FILE NO.: PPR-2254

EPC STORMWATER REVIEW COMMENTS
IN ORANGE BOXES WITH BLACK TEXT

CHEROKEE METROPOLITAN DISTRICT
LIFT STATION NO. 1B
EL PASO COUNTY, COLORADO

EROSION CONTROL PLAN

SHEET NO.  
**CE1.0**

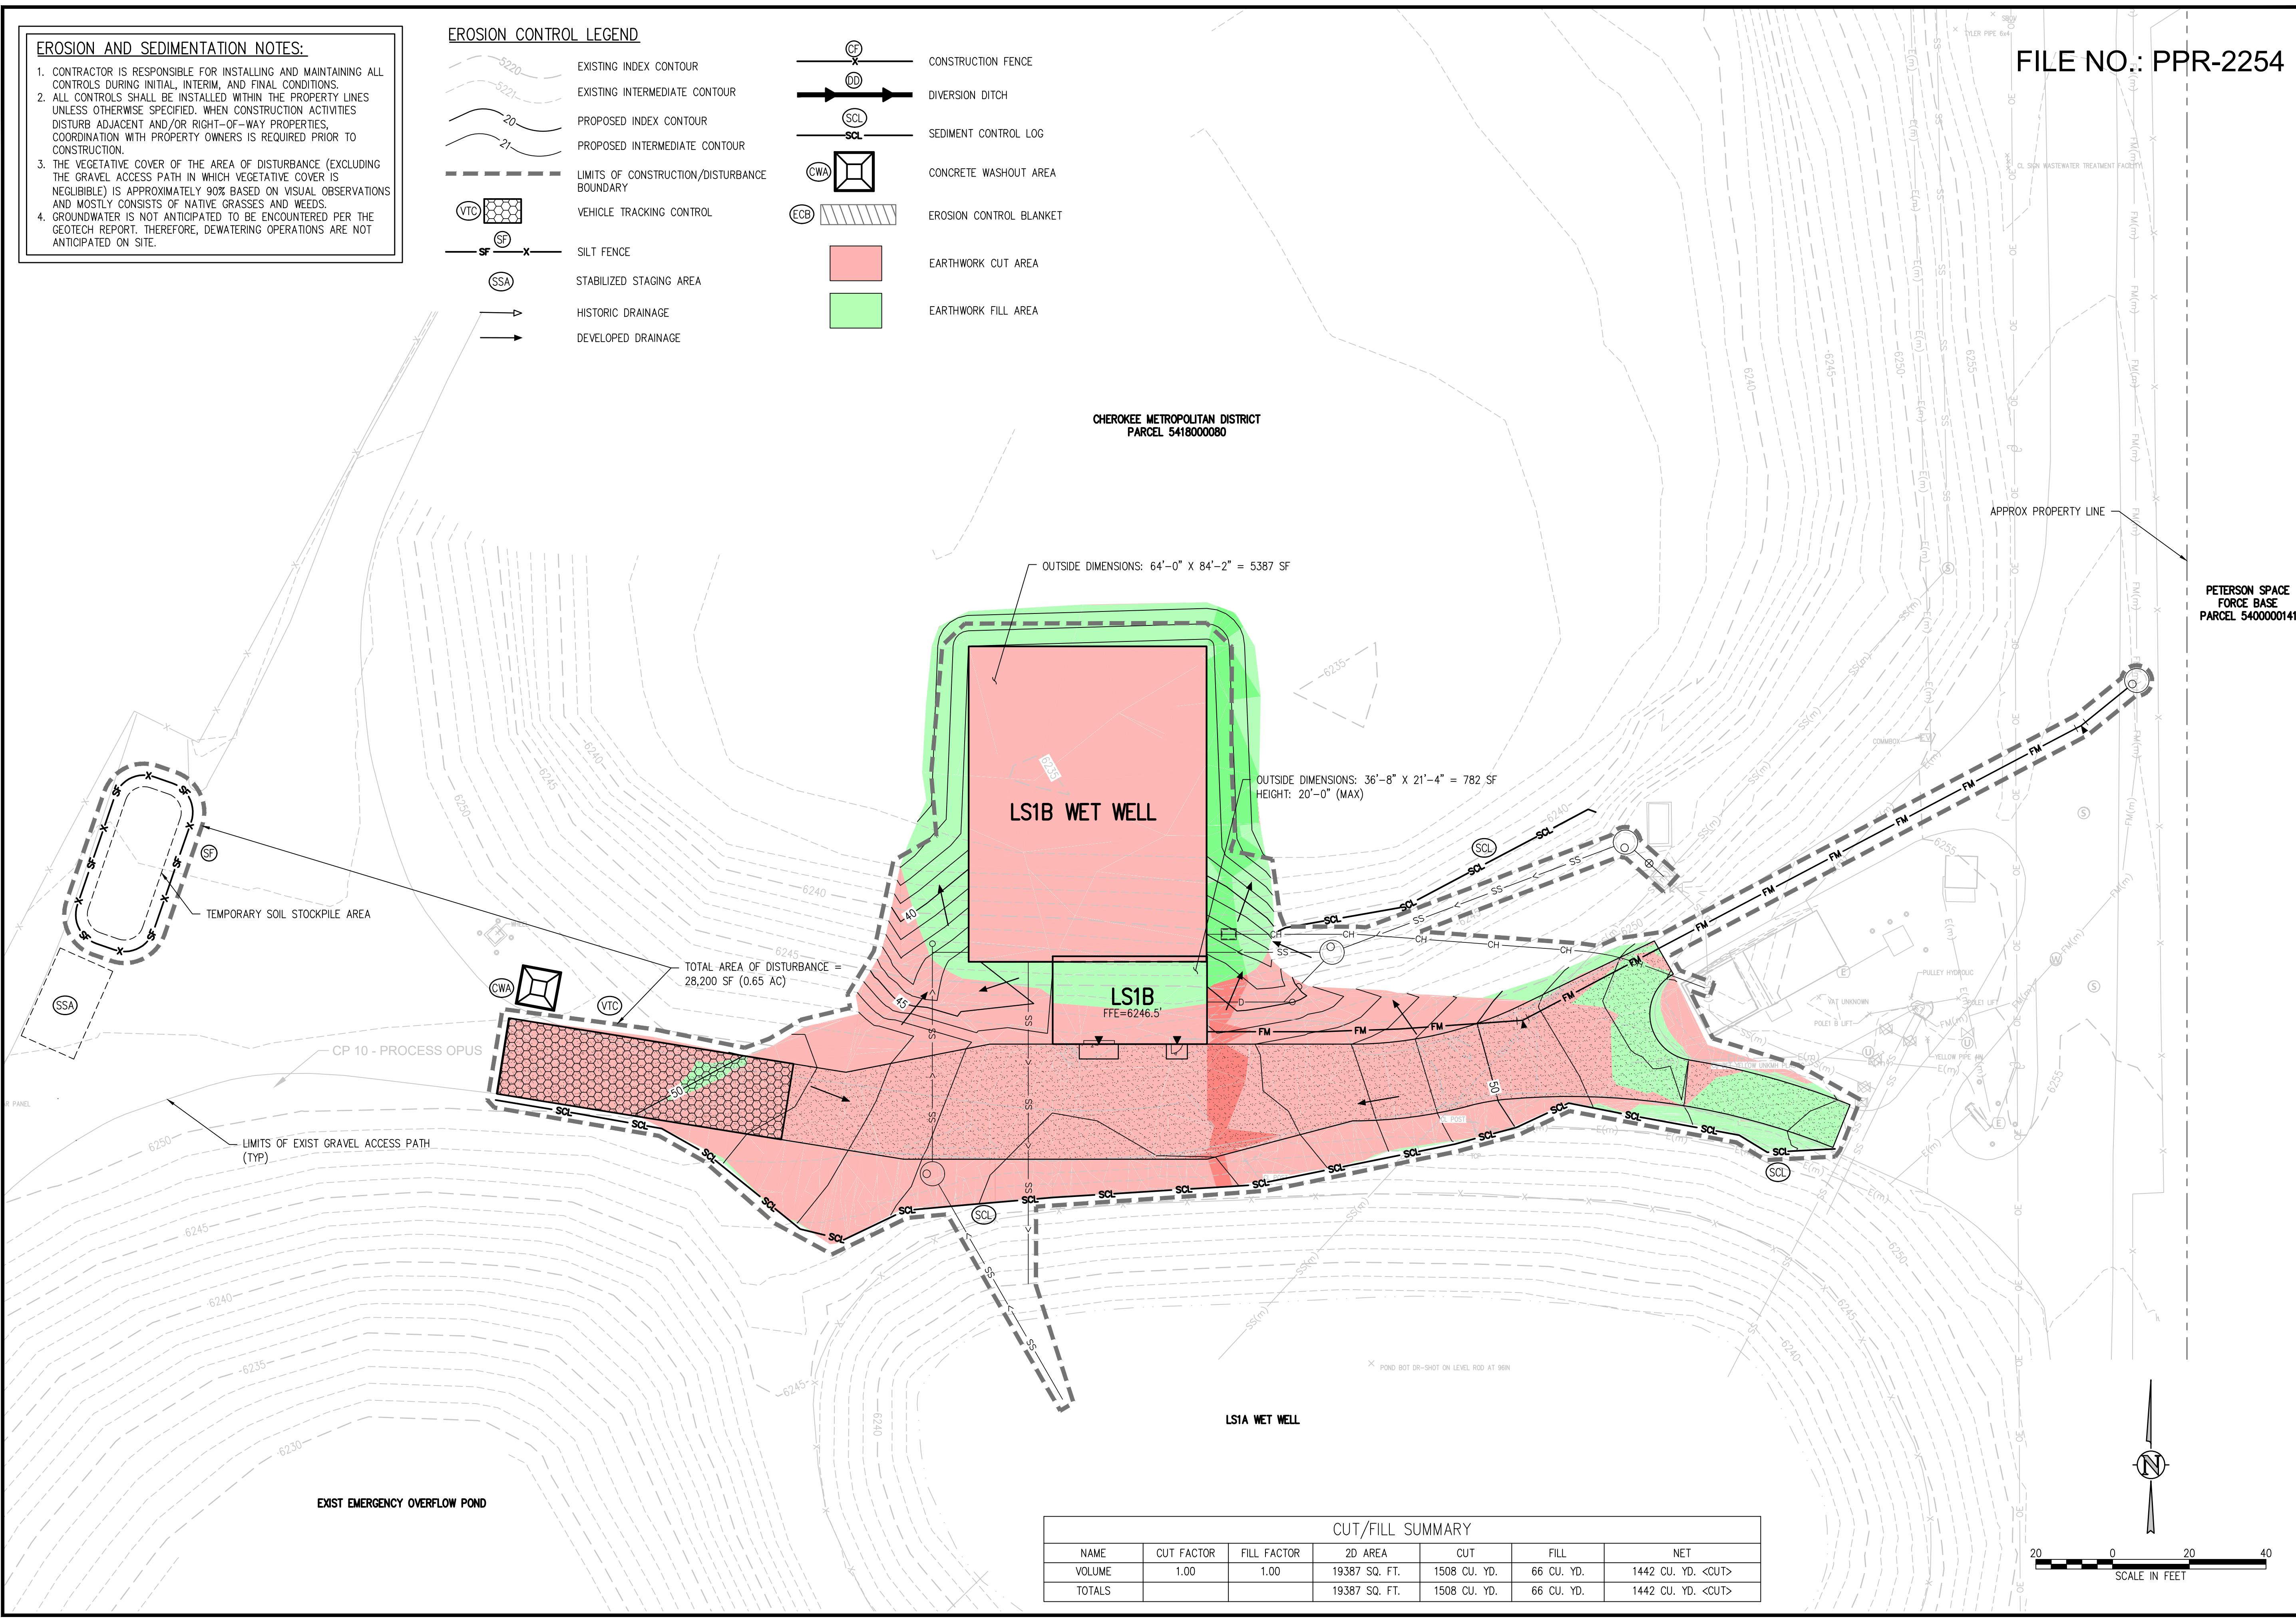
Label all proposed temporary construction BMPs by phase of implementation (initial, interim, final).

Please add sheet index
Please add GEC signature blocks (remove from SDP sheet)

Denote Floodplain area

Can you explain or depict how these comments are being mitigated or addressed via the site plan and grading and erosion plan.

Please add construction traffic ingress/egress route and construction entrance/exit points from the public ROW
A VTC appears to be needed where the dirt road/driveway ends at the HWY 24 access frontage. (~Access Hwy 34).

move SSA and Stockpile areas away from the floodplain.

extend limits of construction/limits of disturbance

Move VTC so that it is the last thing trucks drive over before leaving the Site. Otherwise equipment will constantly drive over VTC causing maintenance issues and trucks leaving the site will pick up sediment after the VTC but before leaving the site.
